Arun District Council
Arun Civic Centre
Maltravers Road
Littlehampton
West Sussex BN17 5LF
Planning & Building Control General Enquiries
Tel: (01903) 737756 Fax: (01903) 730442
Dx: 57406 Littlehampton
Minicom: 01903 732765
e-mail: planning@arun.gov.uk
website: www.arun.gov.uk/planning

Application No: AW/325/21/HH
Site Address: Blue Haze 37 The Drive Aldwick PO21 4DT
Description of works: Erection of single storey side/rear extension, front porch extension and detached garage to front
(This application may affect the character and appearance of the Craigwell House, Aldwick Conservation Area)

Thank you for your internet representation made on 9th November 2021 which has been recorded as an objection with the comments as follows:

BLOCK PLAN
SCALE 1:200

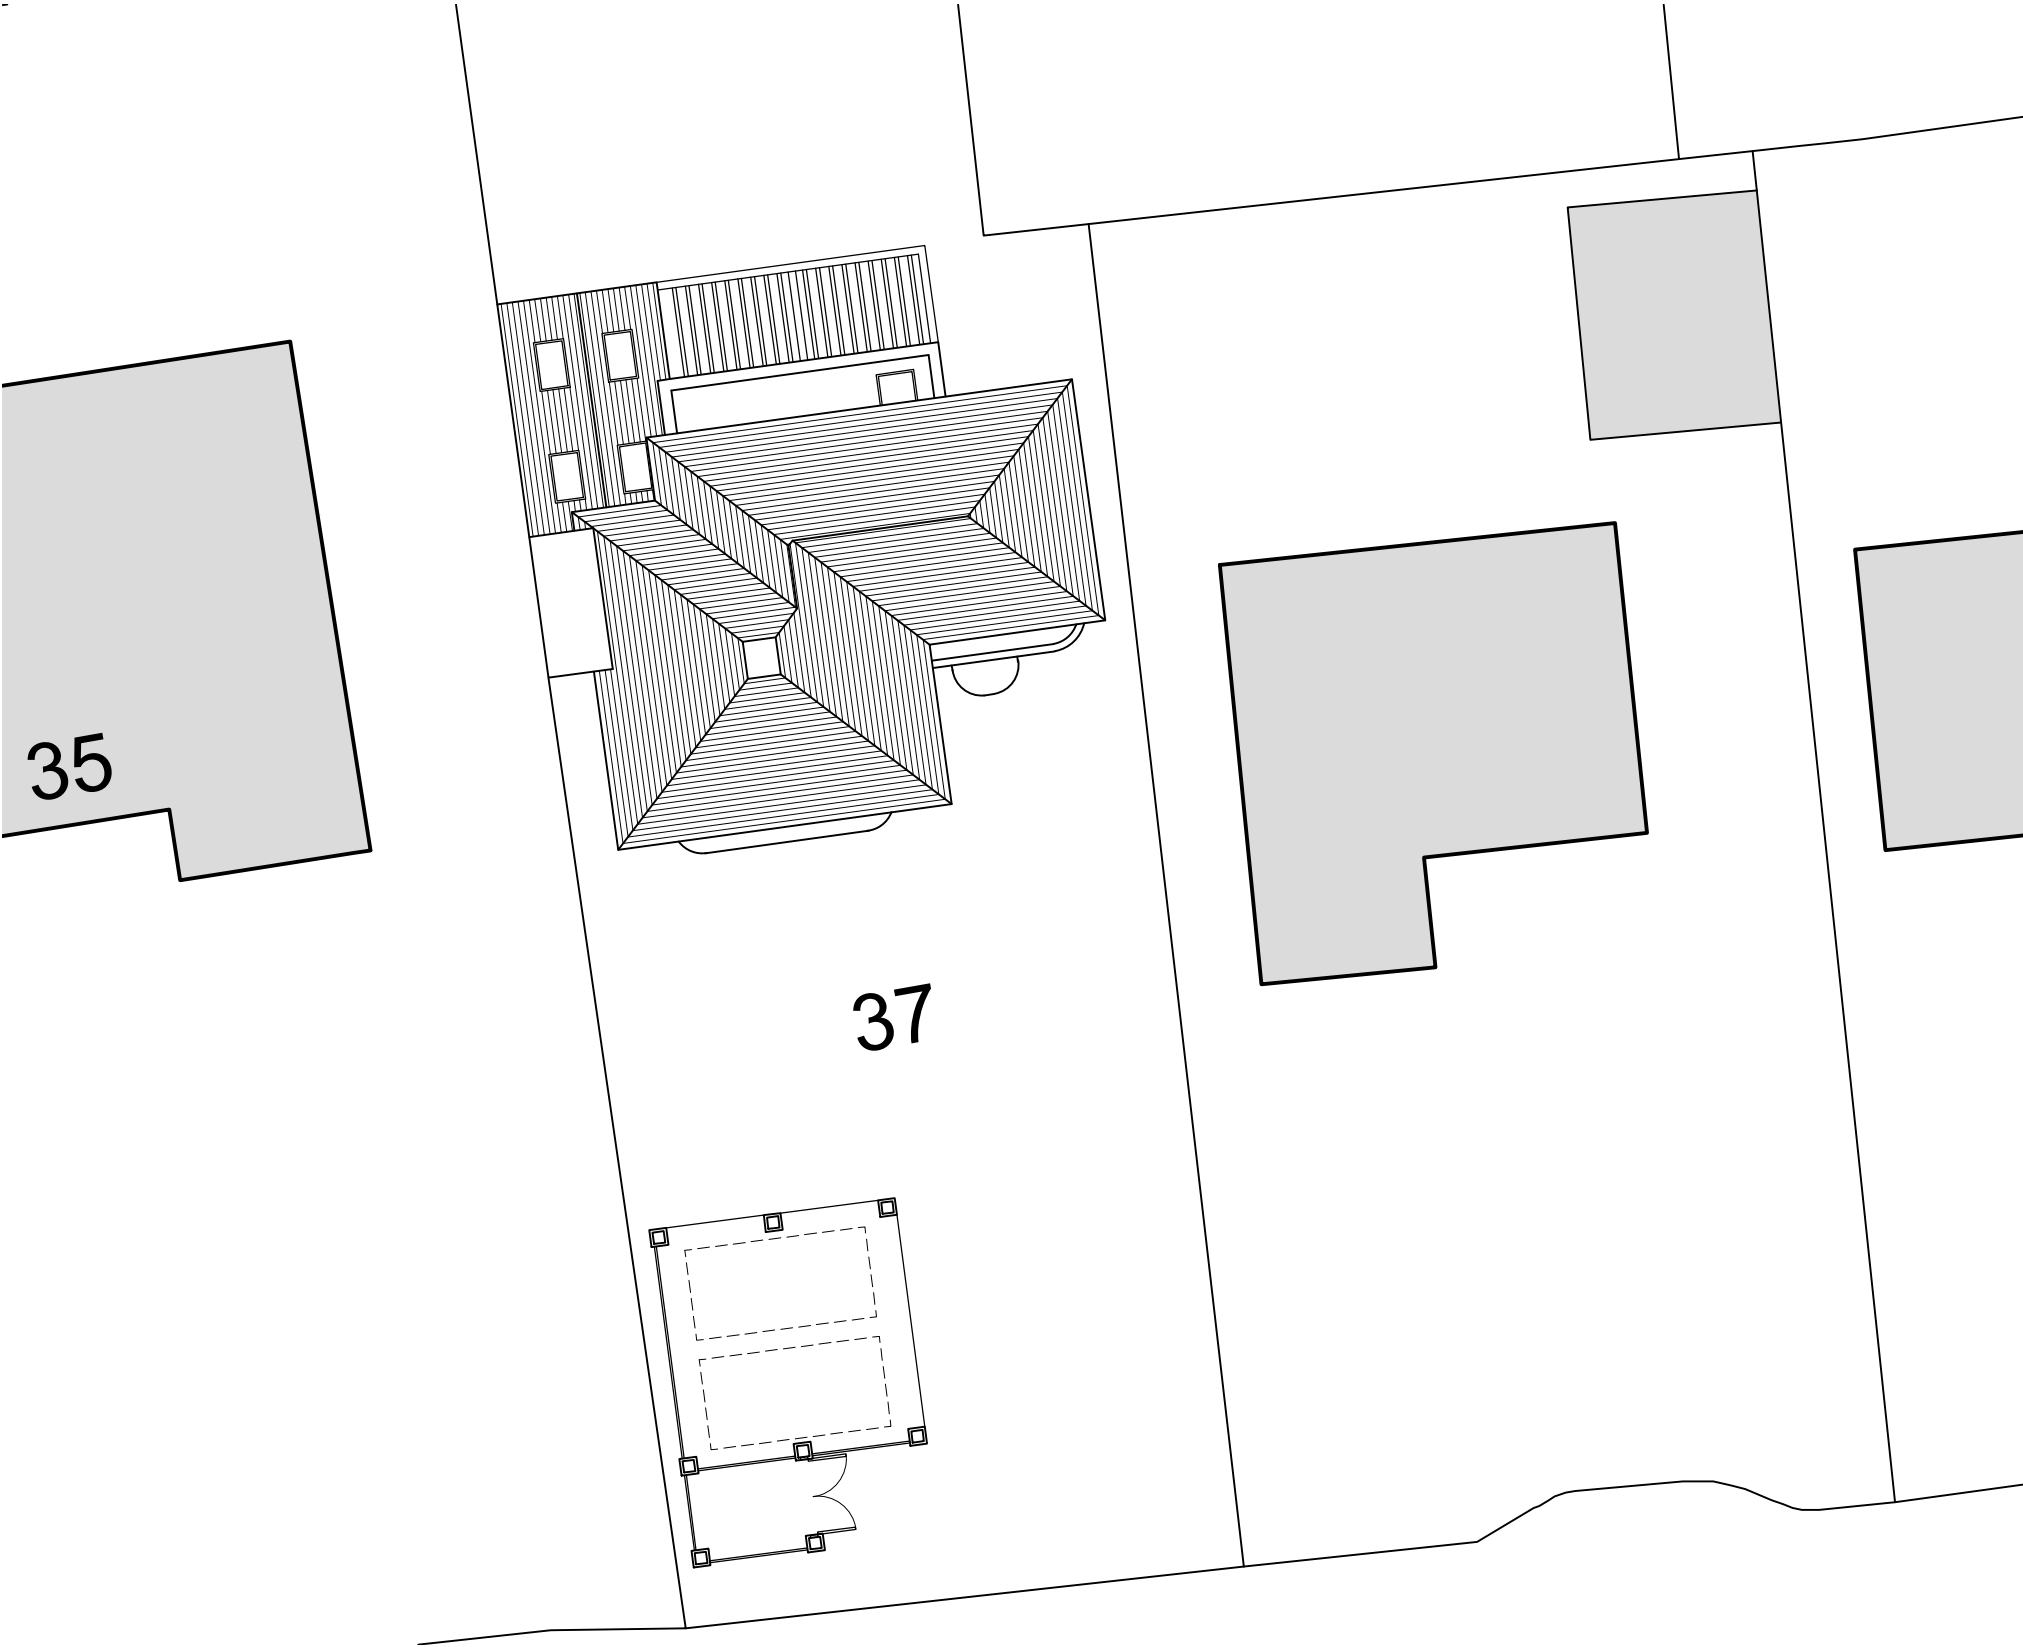
On the whole we feel the proposed works would make the whole property too large for the small site it is on and would spoil this lovely serene and leafy conservation area.

PROPOSED GROUND FLOOR PLAN

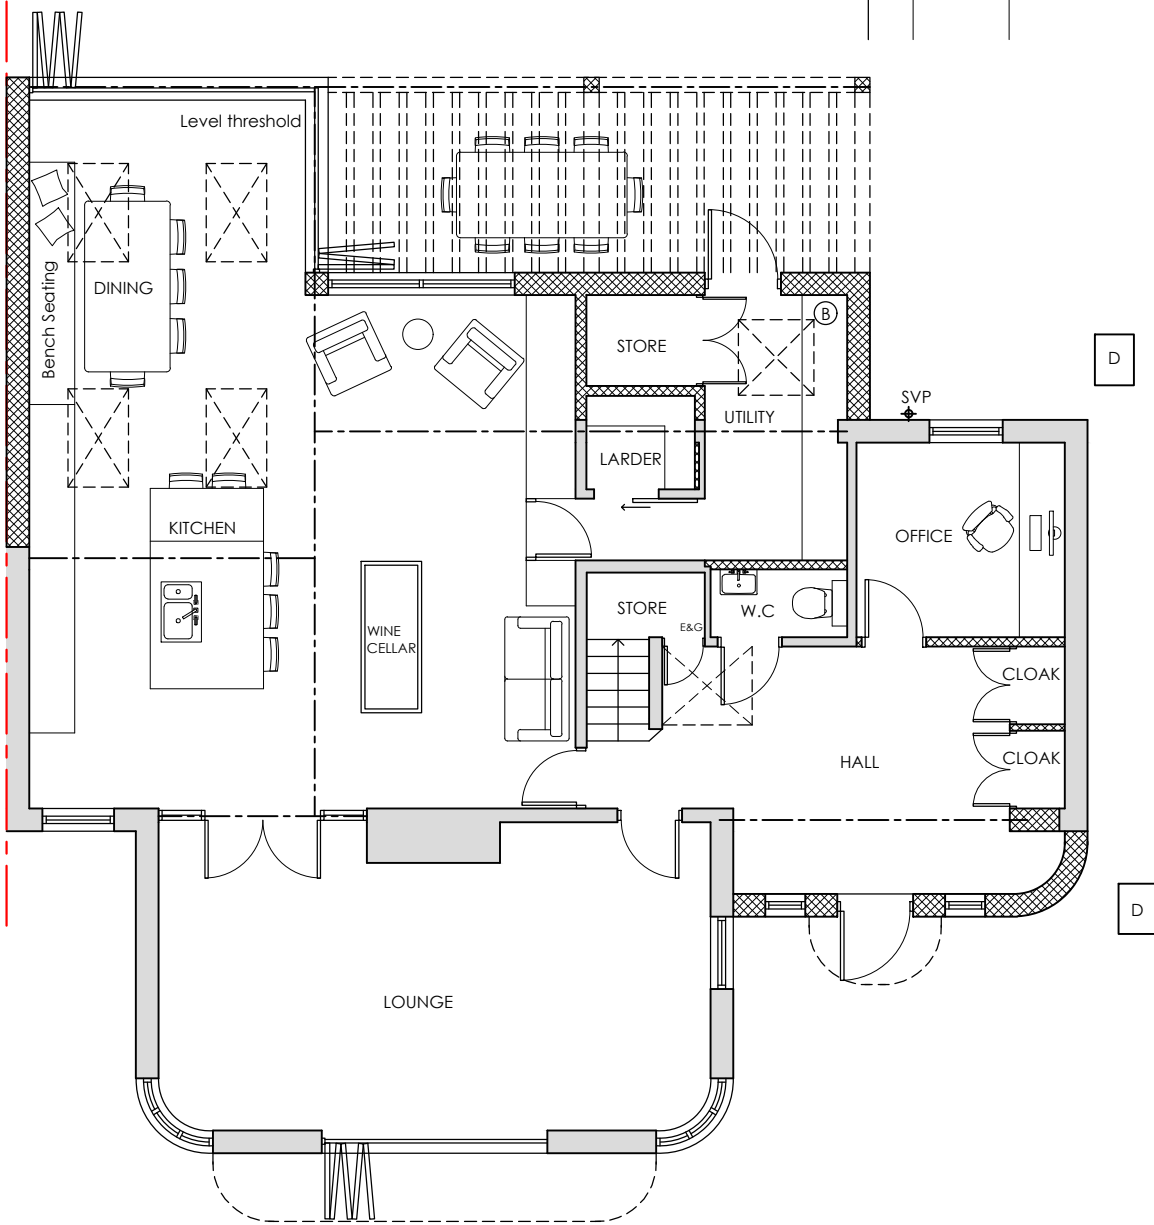
The proposed extension would have an overbearing effect on our bungalow (No 35 The Drive). Although single storey it would have a pitched roof and extends much too far from the back of the existing property.

The extension appears to be right on our boundary wall and allows no space for maintenance and repair of either our wall or the proposed extension.

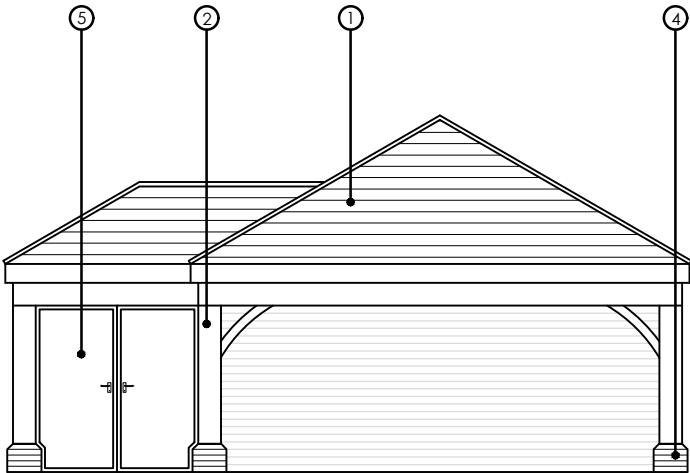
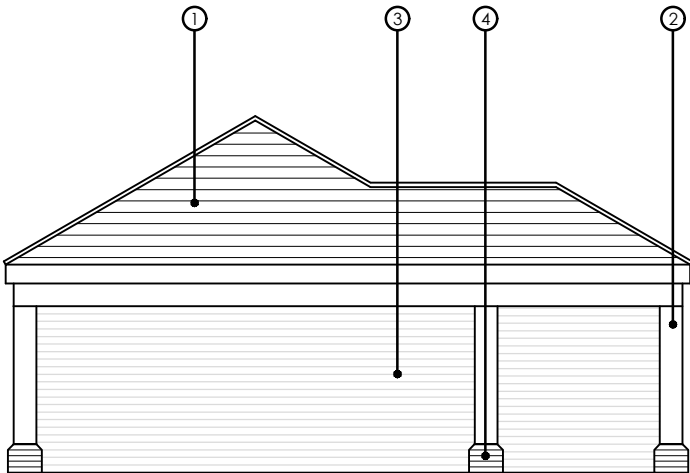
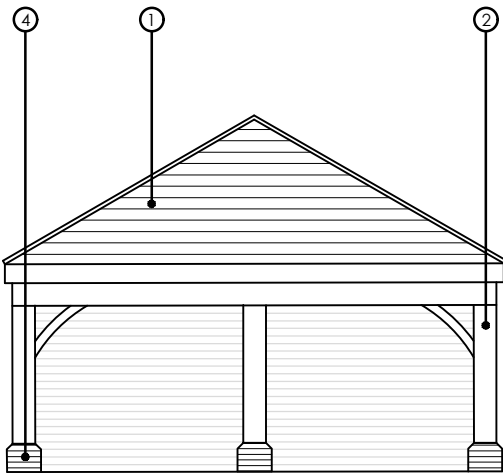
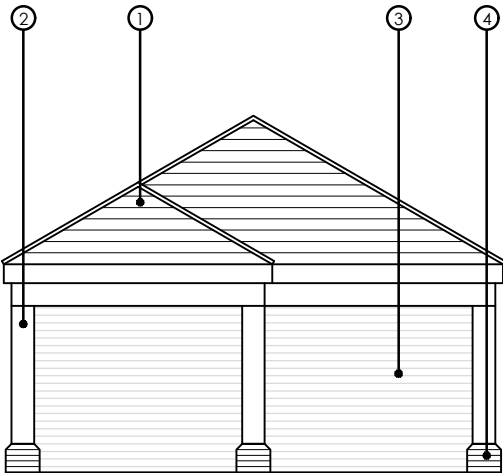
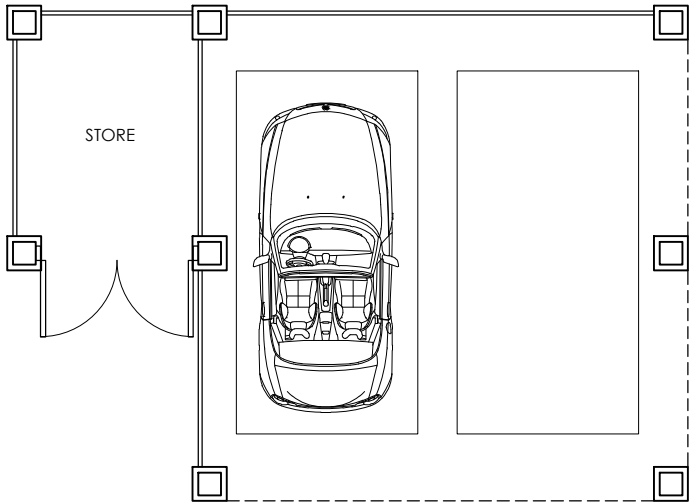
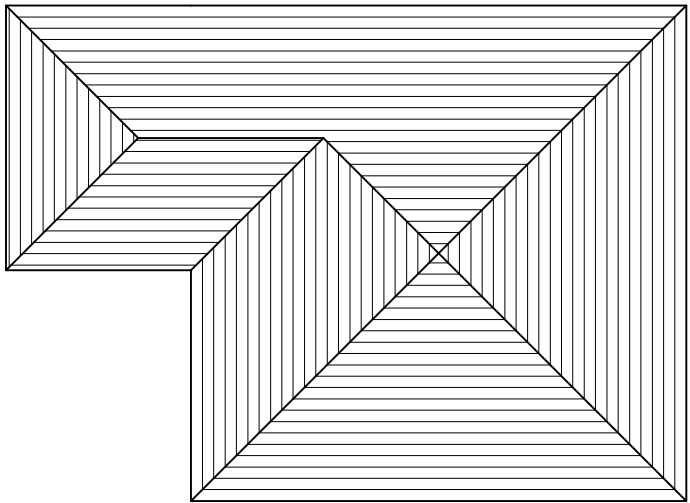
The plans for the carport/garage/store are sited right at the front of the property and way beyond the existing building line that is allowed in this conservation area. They have however allowed a space at the back of the garage for maintenance etc. Quite a few small trees and shrubs would have to be removed to allow for this building work and we feel this would set a precedent for other homeowners to do the same.
